Recommendation Report for Planning Permission for Works or Extension to a Dwelling

REF NO: BR/189/21/HH

LOCATION: 2A Merchant Street
Bognor Regis
PO21 1QH

PROPOSAL: Installation of 1 x rear dormer

Proposed Rear Extension Plans and Elevations Planning
Date February 2021
Scale 1:50

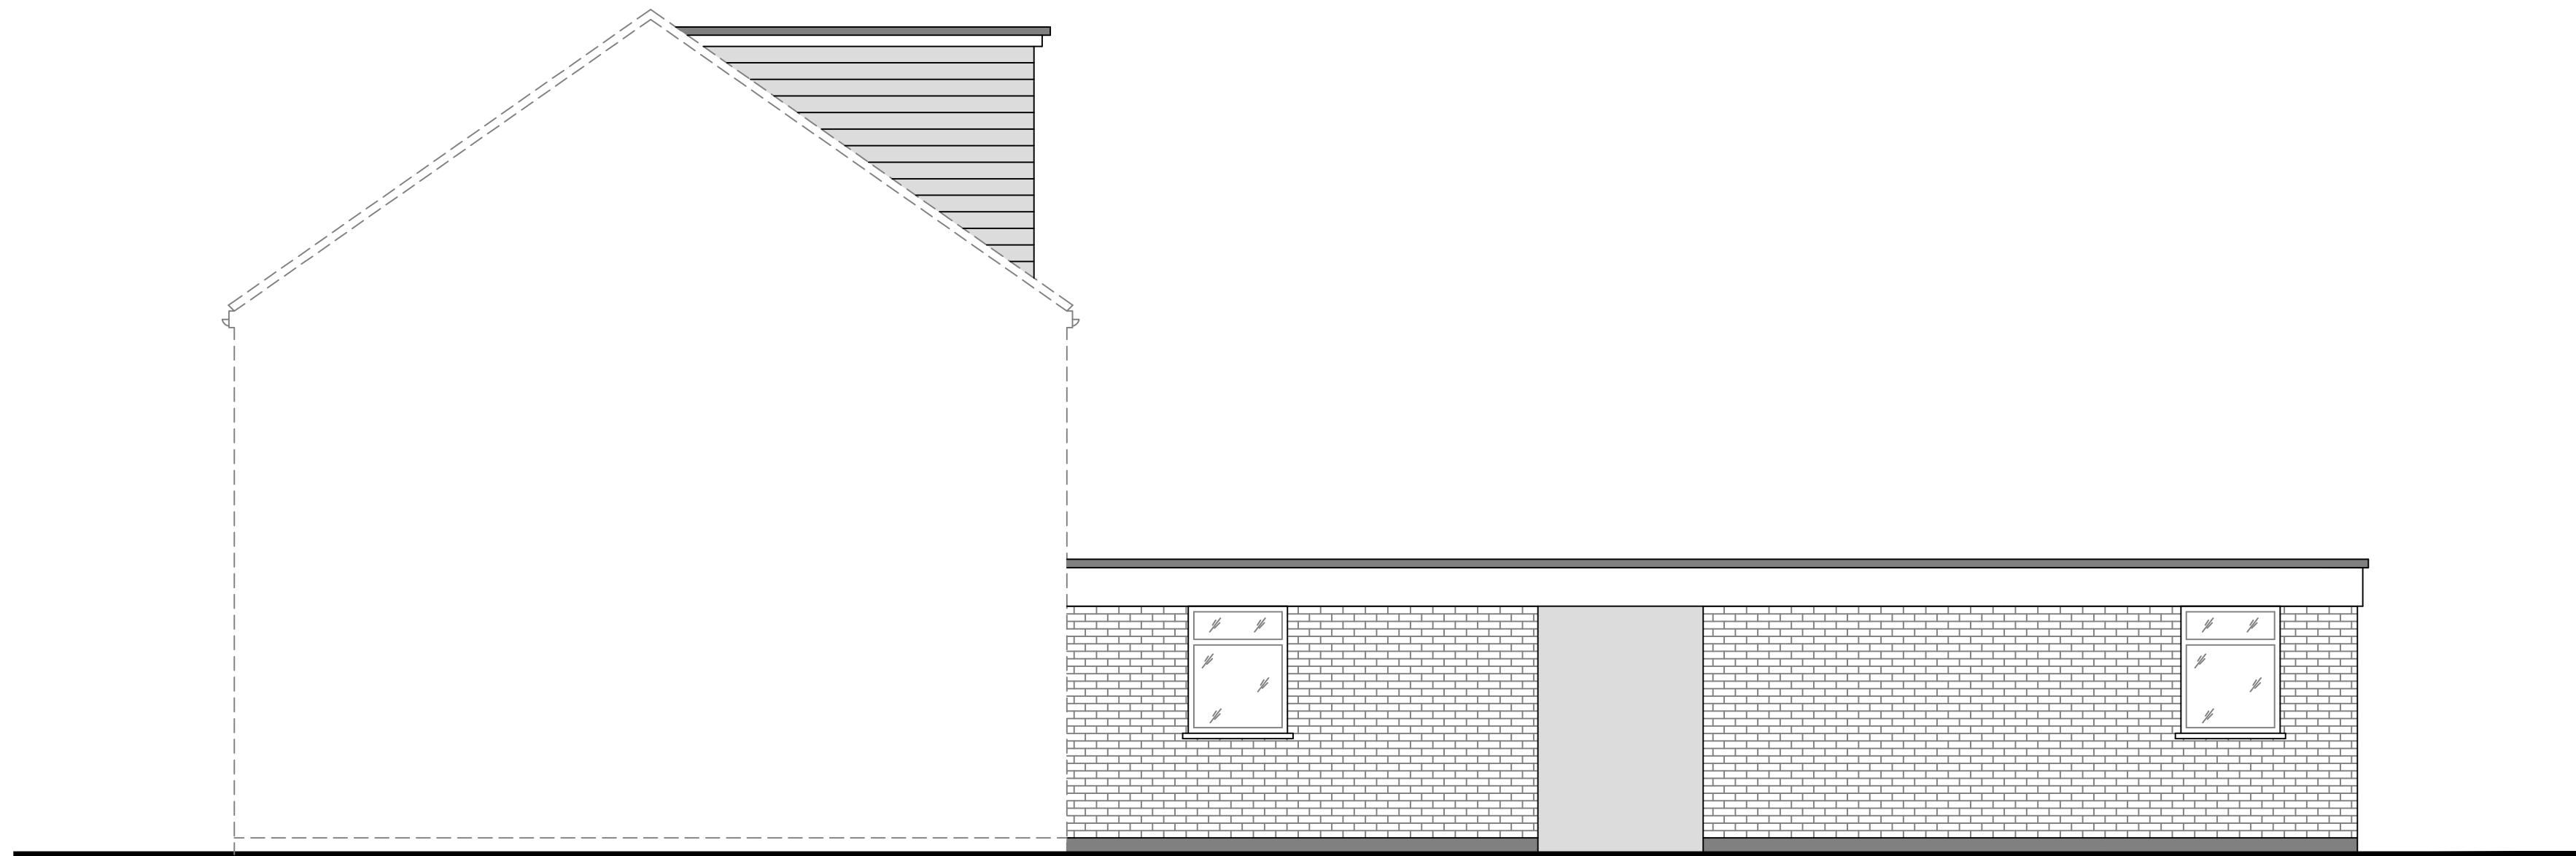
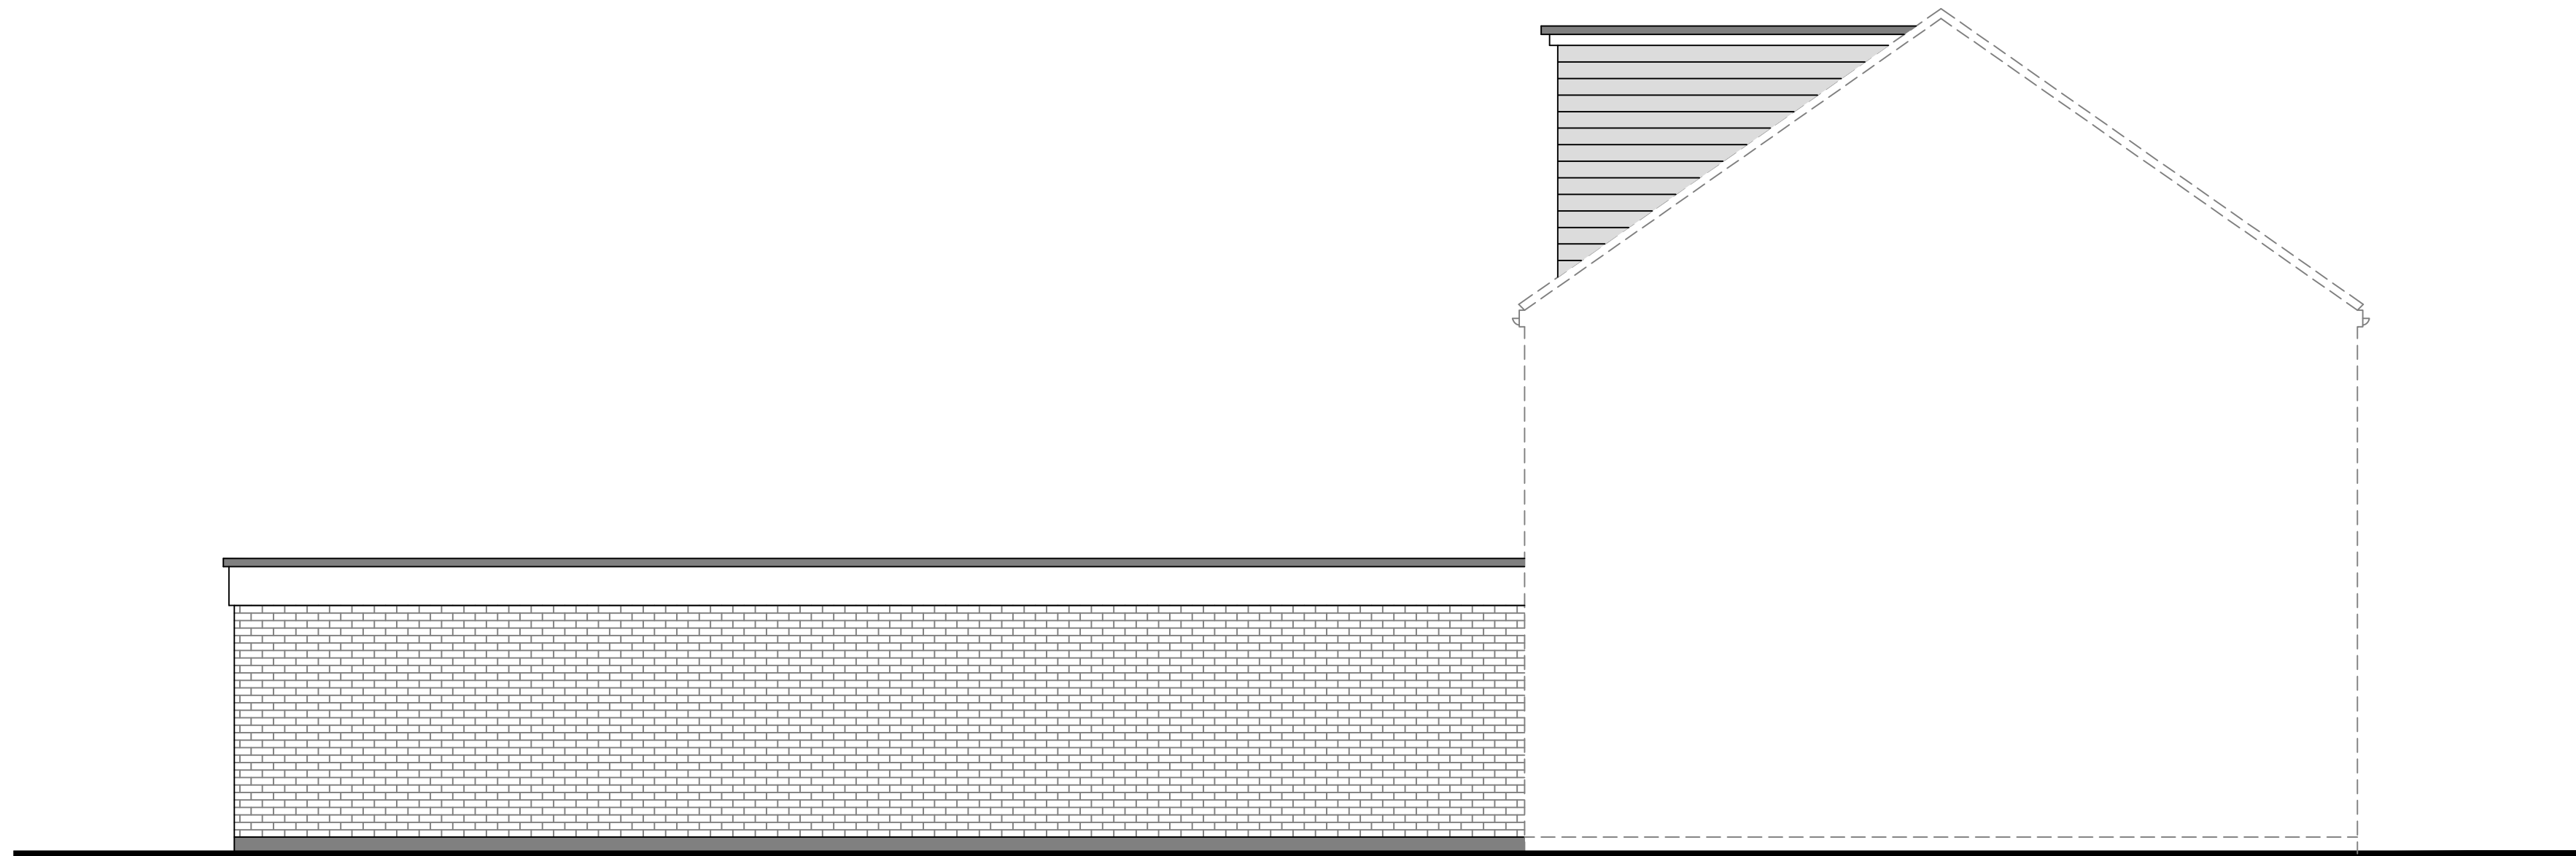
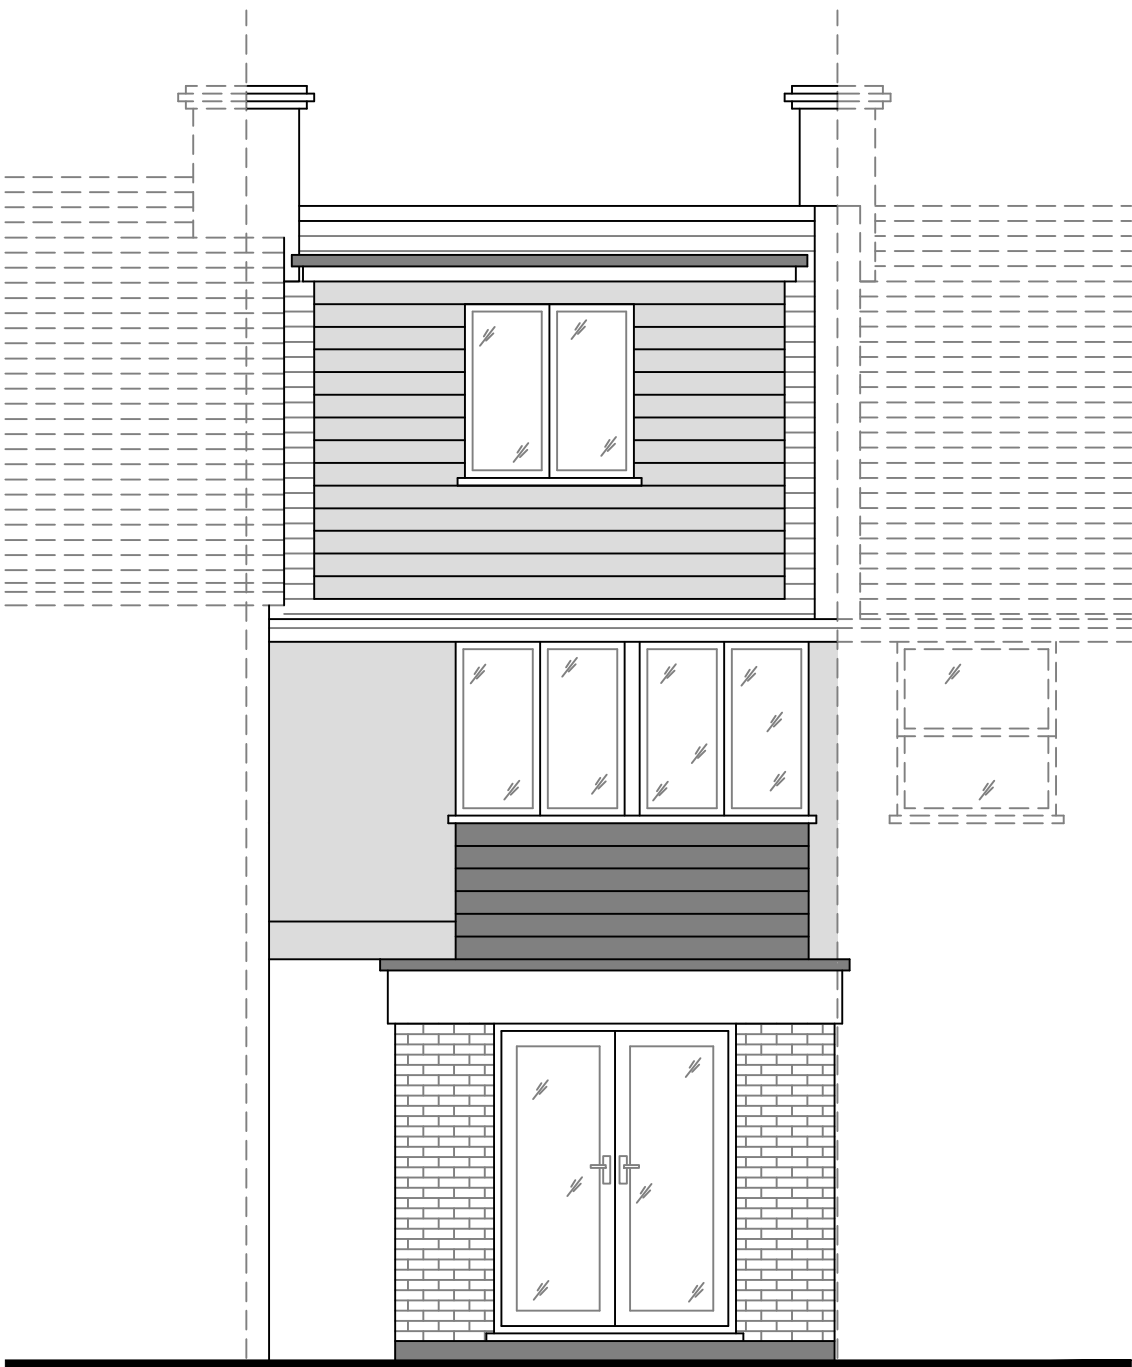
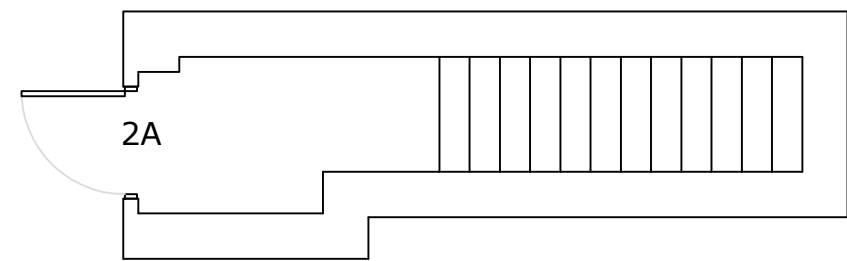
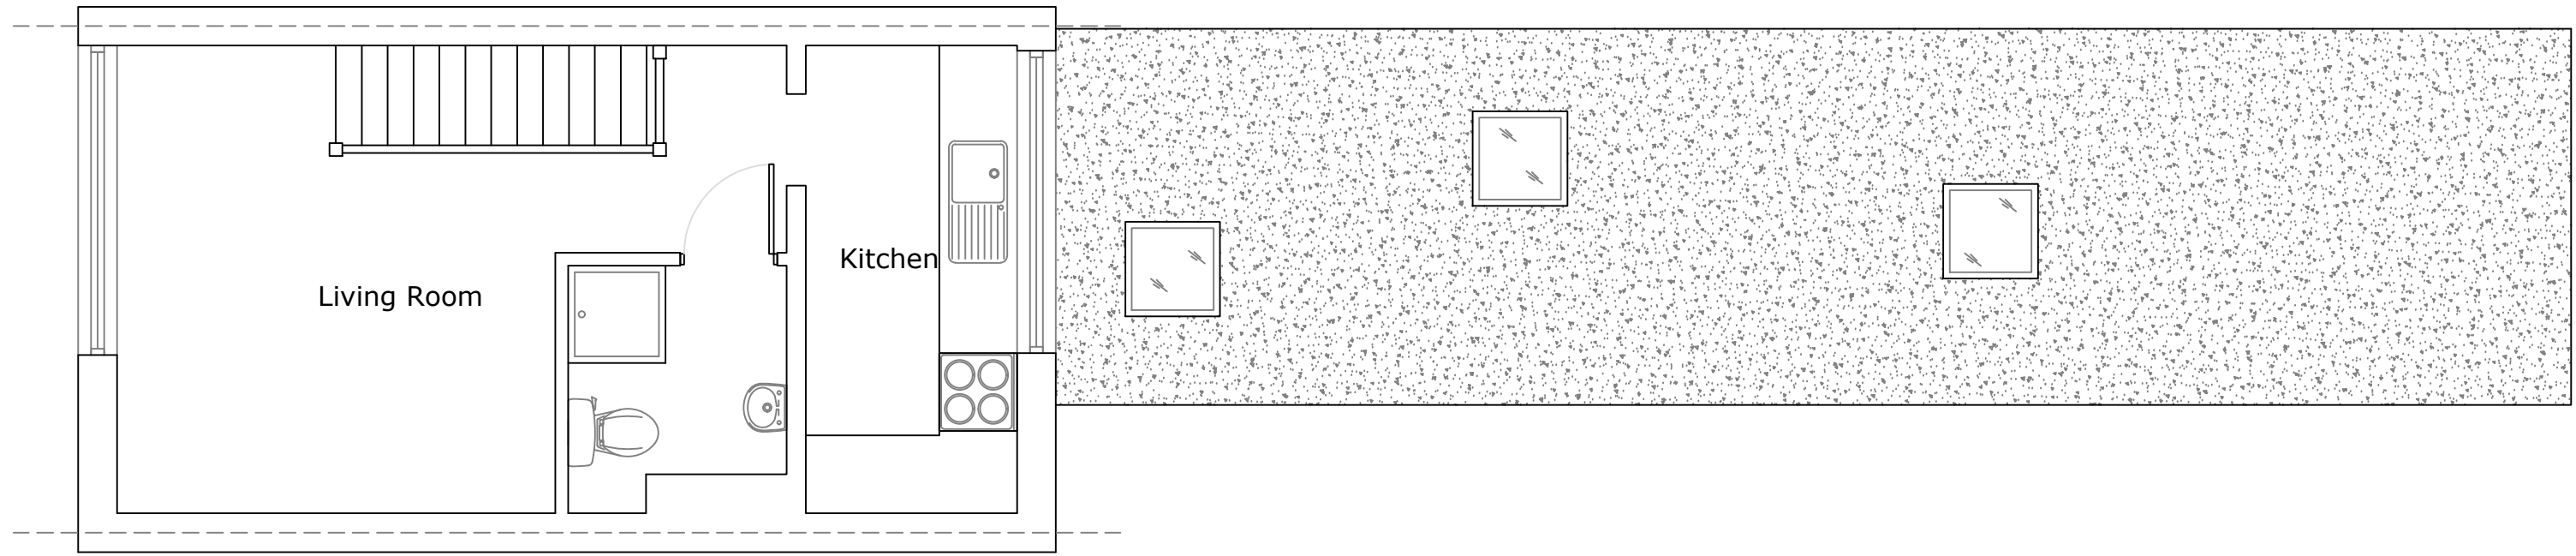
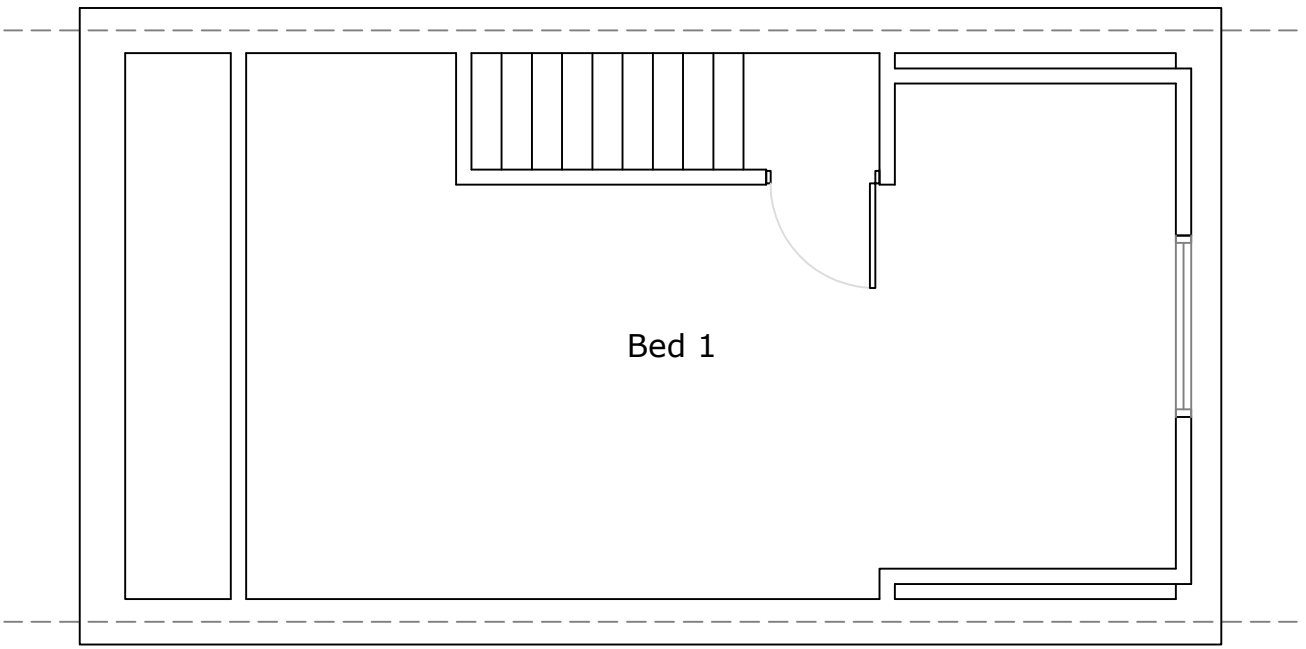
The current proposed dormer would be of a much larger scale, extending almost full-width across the rear roof and only set up from the eaves line around 100mm (albeit it would be set down from the main ridge by around 300mm) and its height would extend over 50% of the height of the main roof. It would appear as a bulky, out of proportion and box-like addition and would fail to appear visually subservient to the main host building. This would fail to accord with policies D DM1 and D DM4 and the ADC Design SPD in respect of scale and visual subservience of additions to buildings. It would also fail to complement the existing character of the surrounding townscape in terms of other dormers along this terrace, again in conflict with the ADC Design SPD.

Whilst it is recognised that the proposed dormer would be sited at the rear of the property, and thus would be less visible in public views from within the immediate street scene, with its elevated position it would still be visible from a large number of private views from neighbouring properties/gardens and residential car park to the sides and rear of the application site. Its overly large scale and poor form and design would unacceptably harm the visual amenity of the area, and the proposals would be in conflict with the NPPF, ALP policies D SP1, D DM1, D DM4 and the ADC Design SPD. There is no 'fall-back' Permitted Development Rights (PDR) position of a similar sized dormer being built here under PDR, since flats do not benefit from PD rights.

- 1 The proposed new rear dormer, by reason of its siting, overly large scale, bulk and poor form/design would fail to appear visually subservient to the main host building and would fail to reflect the existing character of the other dormers of this terrace. It would therefore unacceptably harm the visual amenity of the area, in conflict with the National Planning Policy Framework, policies D SP1, D DM1 and D DM4 of the Arun Local Plan and the Arun District Council Design SPD.
